Ref:	Question:	SCC Response:
1.9	<p>Article 13 – Traffic regulation measures With reference to recent DCO precedent, should Article 13(5)(c) be added to ensure adequate notification of the powers under Articles 13(1) and 13(2): “(c) displayed a site notice containing the same information at each end of the length of road affected”?</p>	<p>We are content with the proposed amendment.</p>

- Site boundary
- Scenario 2b Construction Routes**
- Light Vehicle Route
- Heavy Vehicle Route
- Temporary Construction Haul Road
- Road Network**
- A Road
- B Road
- Motorway

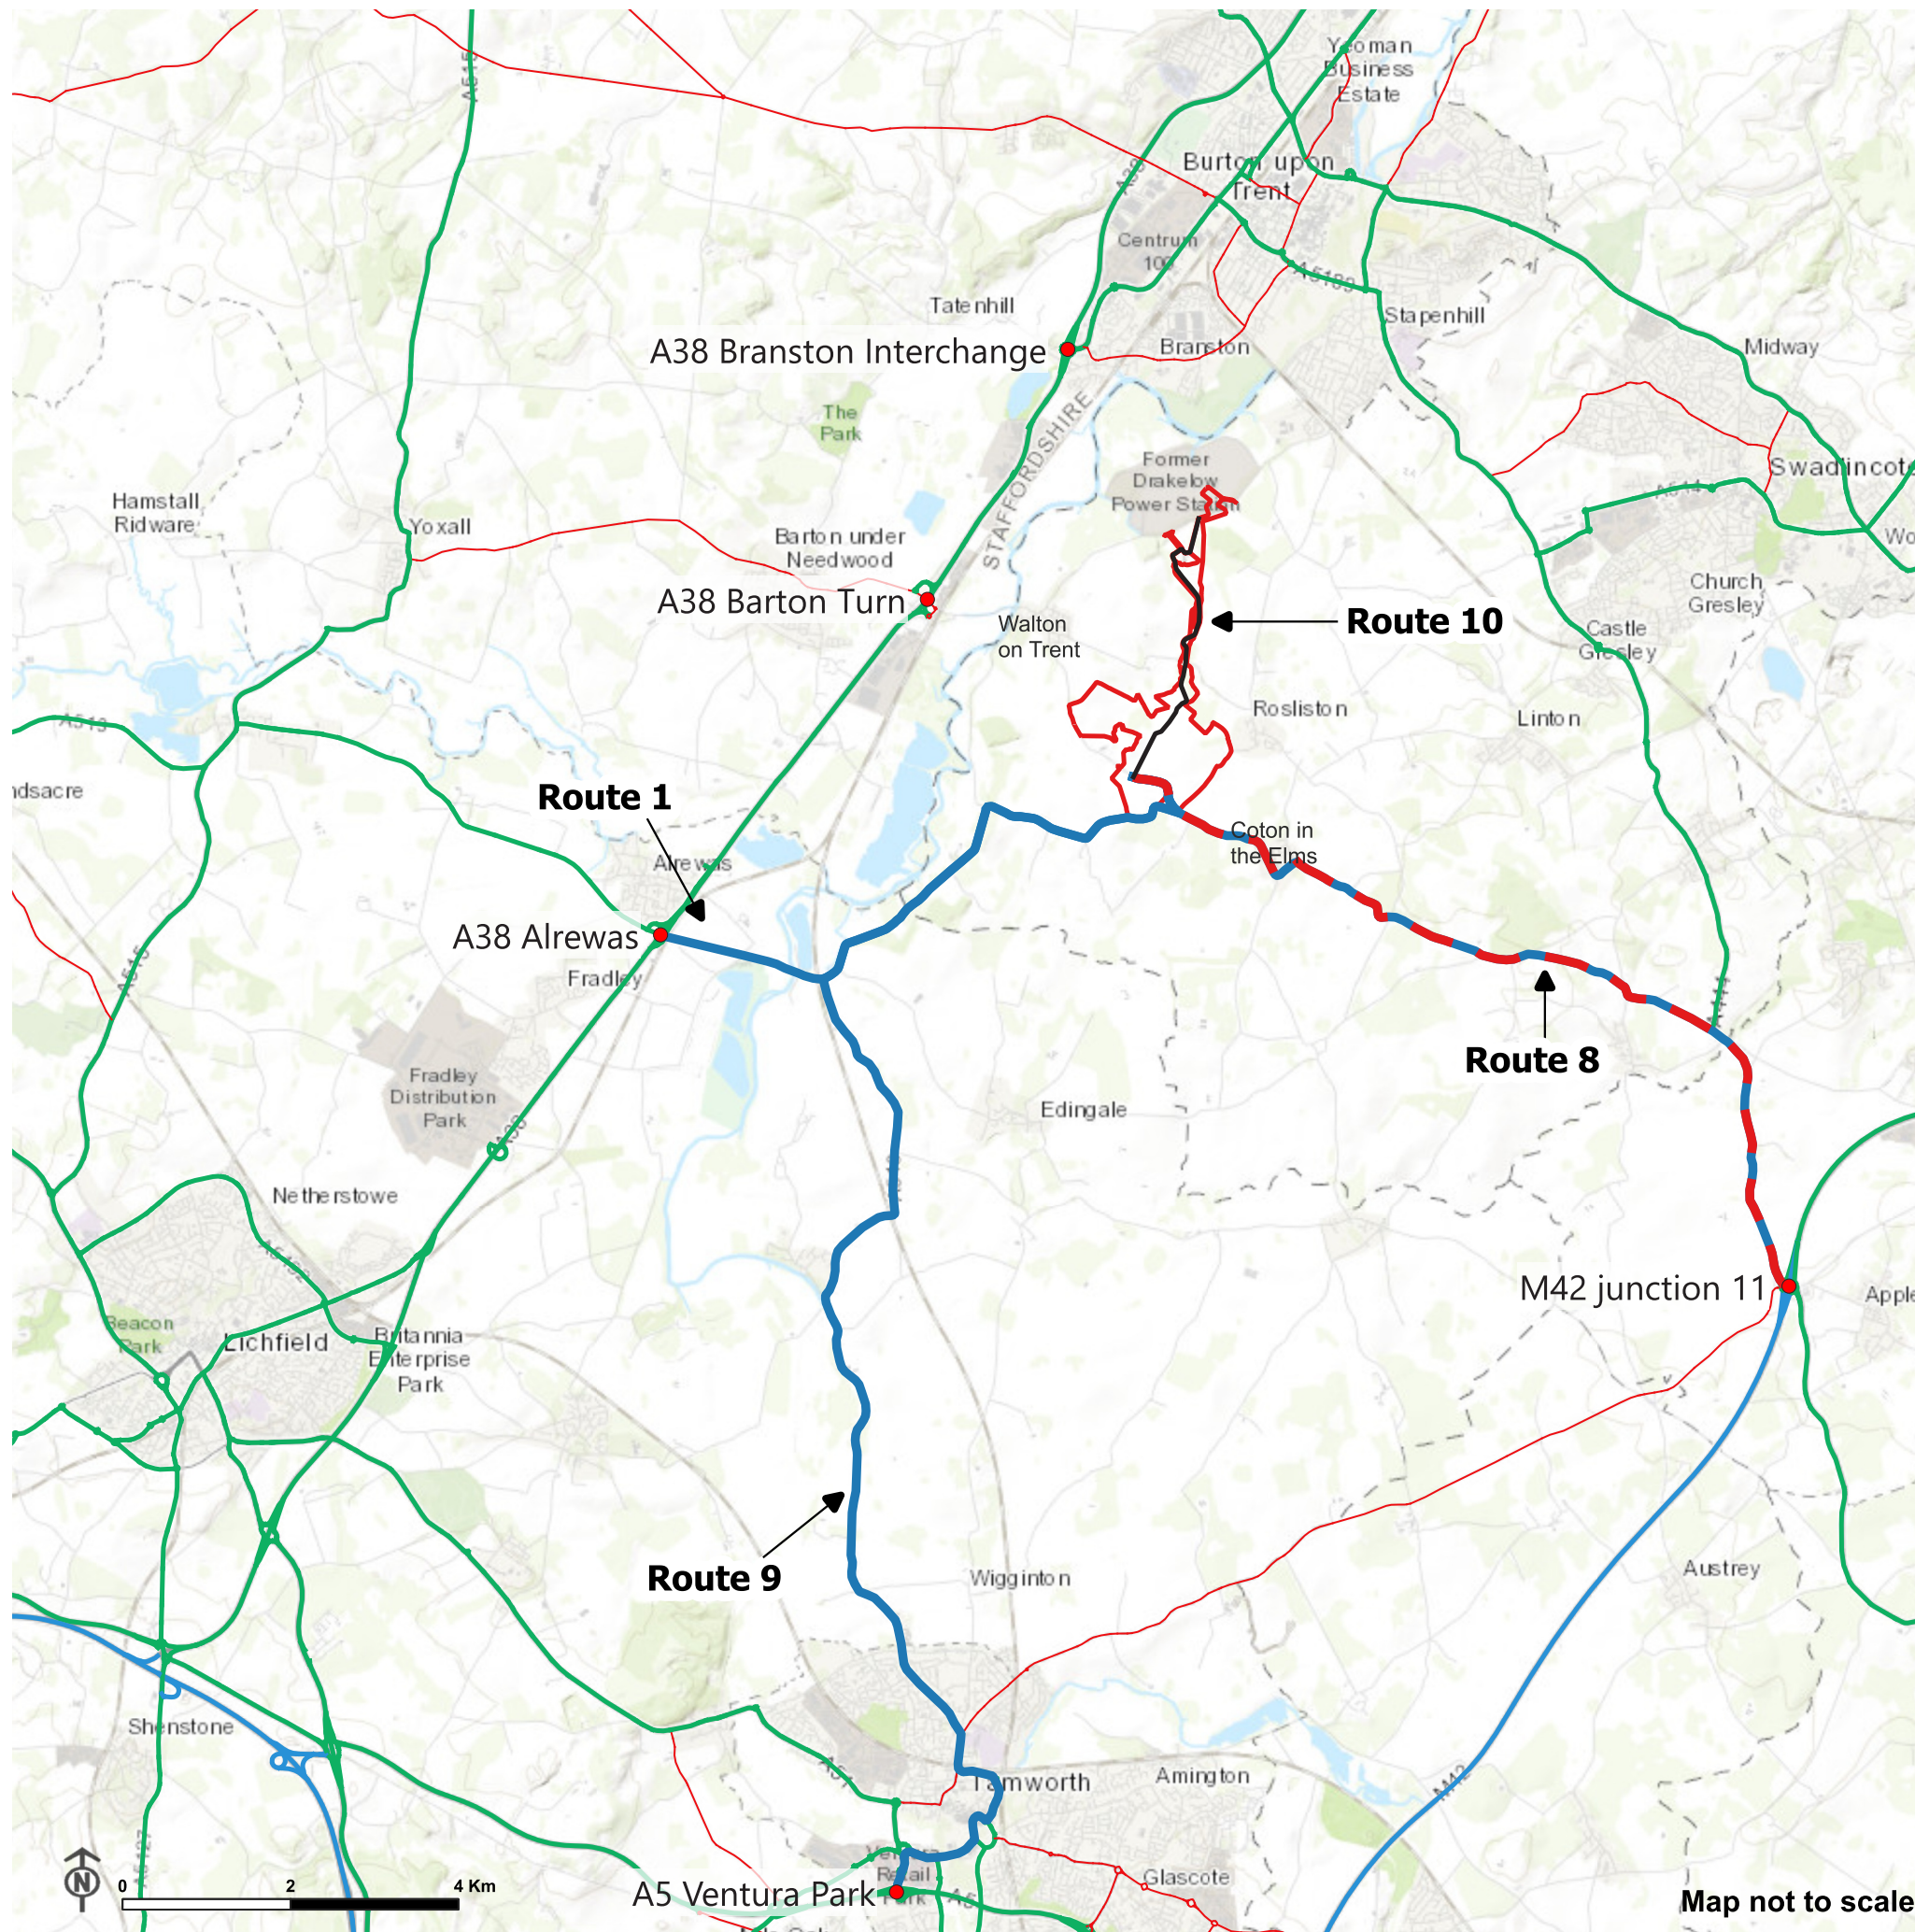
11.2	<p>Securing the construction traffic routes</p> <p>The Applicant [REP1-025 response to question 11.4] says that subject to responses from others, it is content to amend the Outline CTMP [REP1-009] to secure that:</p> <ul style="list-style-type: none"> • construction route Scenario 2A to only be used if Scenario 1 (using Walton-on-Trent bypass) is not available; and • construction route Scenario 2B to only be used if Scenarios 1 and 2A are not available. <p>a) Are DCC, SDDC, or SCC content for the Outline CTMP [REP1-009] to be updated to secure the above?</p> <p>b) Please could the Applicant, following discussion with DCC, SDDC, and SCC, update the Outline CTMP [REP1-009] accordingly?</p>	<p>a) We are content with the first bullet point. However, in relation to the second bullet point we have an outstanding matter raised in relation as to why routes 2A and 2B cannot be used in conjunction with one another if route 1 is not available (see Q11.4). For example Route 2A will not be available during the afternoon school run period and potentially for a period overlapping the AM network peak hour. It is our understanding that assessment has only been undertaken to compare each route being used in isolation and not whether impacts could be further lessened by spreading the load over two routes should the preferred scenario 1 be unavailable.</p> <p>The OCTMP can only be agreed when the issue has been resolved. Should the ExA determine routes 2A and 2B should be kept separate then the wording proposed in the OCTMP as set out in the two bullet point is acceptable.</p>

11.4	<p>Construction traffic – SCC concerns</p> <p>SCC [REP1-031] raise concerns including in relation to:</p> <ul style="list-style-type: none"> • why routes 2A and 2B could not be used in conjunction with one another to spread the impacts of construction traffic across the network rather than focussing it on a particular route; • consideration to the movement of young pedestrians who would potentially need to cross and/ or walk along the construction traffic route on their way to/from school 	<p>We have been in discussions with the Applicant post our deadline 1 submission and understand a revised OCTMP will be submitted at Deadline 4. We are mindful of making substantive comments on a document that has yet to be seen by the ExA at this juncture for the risk of causing confusion. However, the revised OCTMP we have seen should address a number of the points we raised, including relation to schools along the construction traffic route 2A by restricting movements during the school run.</p>

<p>for which the Outline CTMP [REP1-021] should restrict the movement of HGV traffic on route 6 during the morning and afternoon school runs during term time;</p> <ul style="list-style-type: none">• whether the construction of the Drakelow Park development has been accounted for in the impacts of construction traffic;• the consideration given to potential delays at a narrow bridge on Rosliston Road over the railway as construction traffic Route 6 enters Derbyshire;• potential impacts from construction traffic not using prescribed construction routes;• it is not clear whether the dDCO [REP3-008] provides for works to remedy any damage caused and attributable to the solar farm development to be undertaken by the developer or whether there are powers for the local highway authority to agree the detail of the works and approve the workmanship of any work undertaken; and• the Outline CTMP [REP1-021] include provision for recouping of and costs incurred by the local highway authority in undertaking emergency repair work of damage caused by construction traffic. <p>The Applicant's responses [REP3-031] include that during pre-application it was agreed with DCC and SCC that a hierarchy of routes would be supported for HGV, whereas for lighter construction vehicles it was agreed the dispersion of these lighter vehicles across the network would be acceptable;</p> <ul style="list-style-type: none">• paragraph 5.5 of the Outline CTMP [REP1-021] has been amended to require all HGV movements to occur	<p>The principal points of objection likely to remain are:</p> <ol style="list-style-type: none">1. Provisions for the highway authority to recoup costs and/or approve remedial works to the construction traffic route. The OCTMP can set out the basis for how this could take place. However, the DCO does not contain the relevant powers to deliver. Therefore, we suggest a Development Consent Obligation (S106) is required to set out the obligations between the parties and mechanisms for payments to be made. The Applicant has suggested such powers exist in S59 of the Highways Act. However, this power is seldom used due to the need to prove damage has been caused in court. Here we have known construction traffic routes that will experience increased HGV traffic therefore specific provisions should be made to address.2. We are not yet convinced the provisions in the OCTMP relating to ensuring compliance with use of the approved construction traffic routes are suitably robust.

<p>outside of the traditional local highway network peak periods, including School Drop off (08:30-09:30) and School Pick up (15:00-16:00);</p> <ul style="list-style-type: none">• Drakelow Park is currently being built out and construction traffic has been captured in the baseline traffic surveys that were undertaken in 2022;• the average of 14 HGV movements per day with restrictions to HGV movements to occur outside peak periods mean that there is unlikely to be material delays at the railway bridge above those occurring within baseline condition; and• the Outline CTMP [REP1-021] requires contractors to use the prescribed construction vehicle routes such as contractual agreements and financial penalties for breaches thereby discourage use of non-prescribed construction routes. <p>a) Please could SCC set out any remaining construction traffic concerns and suggest how their issues might be resolved?</p> <p>b) Please could the Applicant comment?</p>
